RE: 5 Dartmouth Square, Dublin 6

I refer to the above property and to our application under s.5 of the Planning and Development Act 2000 for an exemption in respect of proposed works to our house.

The second element is that at number 5: "5 Re-landscaping the front garden, without making any changes or works to the existing railings; to provide a gently sloping path to the lower ground level for baby buggies and bicycles." This was refused an exemption. We seek to review this refusal.

Partial Site Plan, Front Garden - PROPOSED

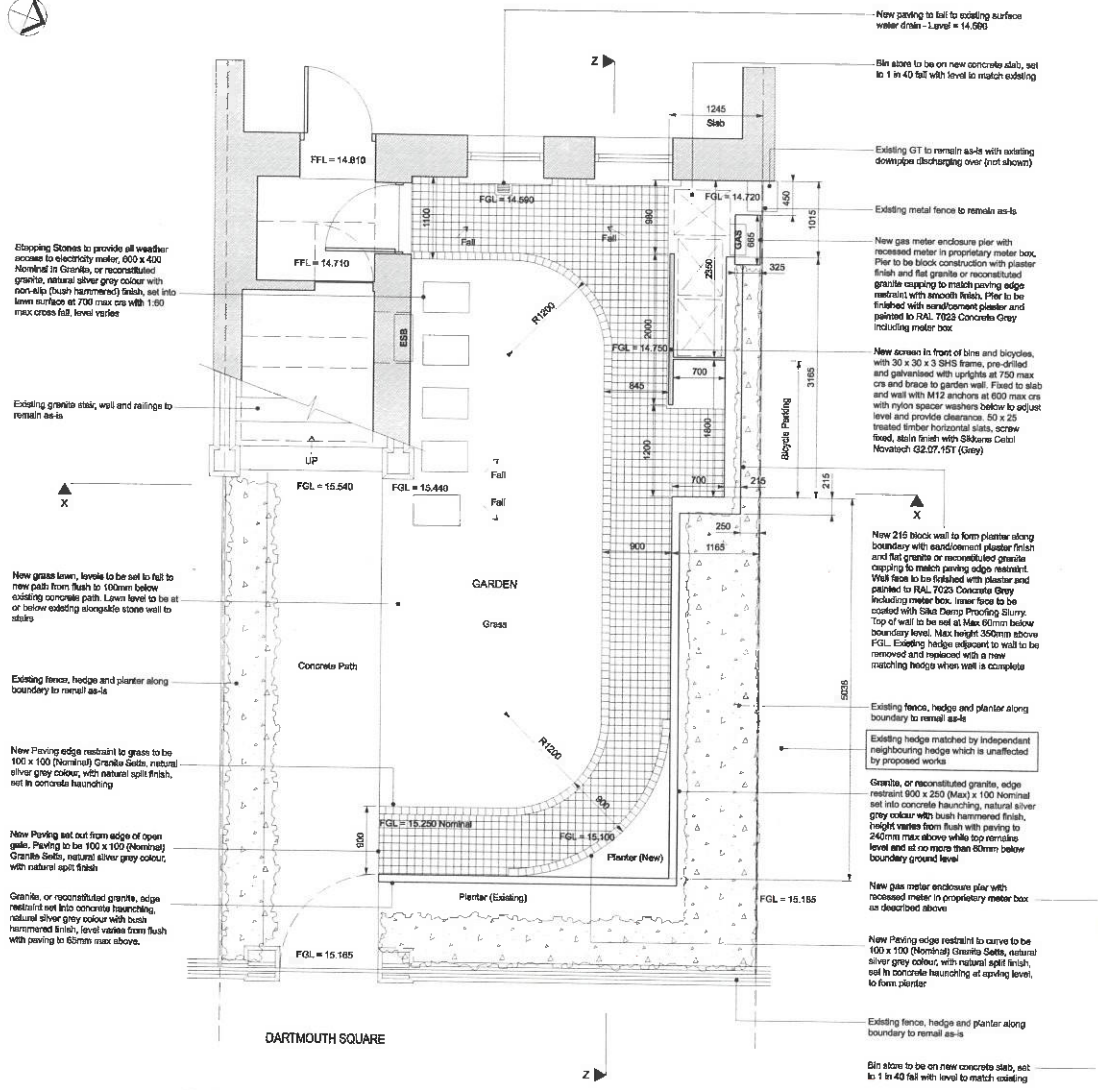
The applicant is requested to provide details on the height/depth/length of the proposed wall along the northern boundary, an elevation drawing showing its height in relation to the front façade of the house and the material to be used in its construction. This information is to include any proposal for a perpendicular wall at its eastern end.

The applicant is requested to provide section drawings showing the alteration to the slope of the garden across both the grass and the new path to assess whether this will have an impact on the protected structure, particularly within the context of the surrounding gardens. These should be dimensioned so that the impact can be fully assessed.

The applicant is requested to submit full details on the colour texture and nature of the material to be used for the path in order for the impact of this on the protected structure to be assessed.

- *Details on the height/depth/length of the proposed wall along the northern boundary* – Heights, depths and length are noted and comprehensively dimensioned on the drawings. Note that the wall is at least 250mm from the existing boundary fence and the top of the wall is no more than 350mm above finished ground level and typically 60mm below the ground level at the boundary.

- *An elevation drawing showing its height in relation to the front facade of the house and the material to be used in its construction* – Sections x-x and y-y on the drawings include elevations that show the proposed low wall in relation to the front facade of the house, and the construction is noted on the Plan

- *This information is to include any proposal for a perpendicular wall at its eastern end* – The wall is only 3380mm long and there's a short return 700mm long at the eastern end and this is 240mm above finished ground level and typically 60mm below the ground level at the boundary.

- *Provide section drawings showing the alteration to the slope of the garden across both the grass and the new path and these should be dimensioned* – Two sections labelled x-x and y-y are provided and both are dimensioned

- *Submit full details on the colour texture and nature of the material to be used for the path* – The Paving material for the path is to be 100 x 100 (Nominal) Granite Setts, natural silver grey colour, with natural split finish
